LY/13/07

PLANNING APPLICATIONS REPORT

DESCRIPTION/ ADDRESS	- Two stable boxes with hay storage and tack rooms (Resubmission following LY/27/06) Crossbush Yard Crossbush Lane Crossbush Arundel
-------------------------	---

312/1

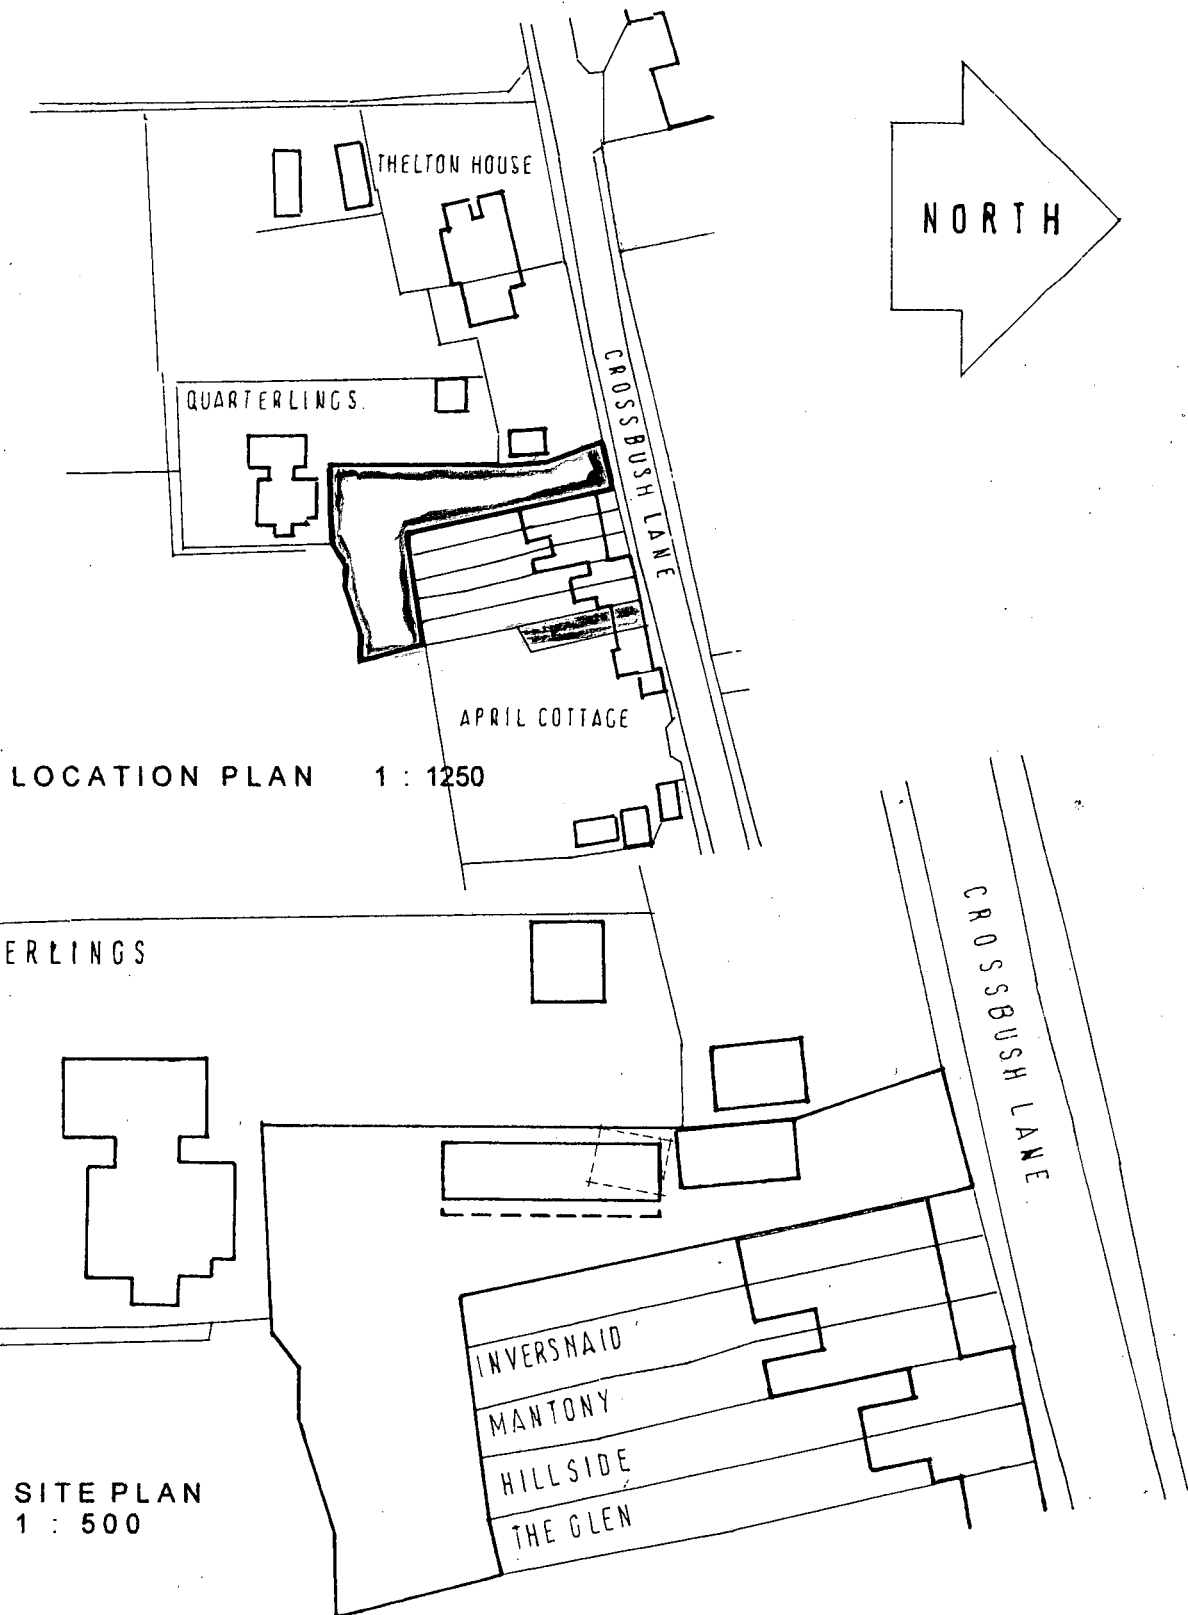
The stables as proposed are of timber construction with a corrugated felt roof and its design is a typical stable block normally found in rural locations. It will be sited 1m from the boundary with the neighbouring property to the west.

- 2 No windows or other openings shall be formed in the west elevation of the stable block hereby permitted without the prior permission of the Local Planning Authority on an application in that behalf.
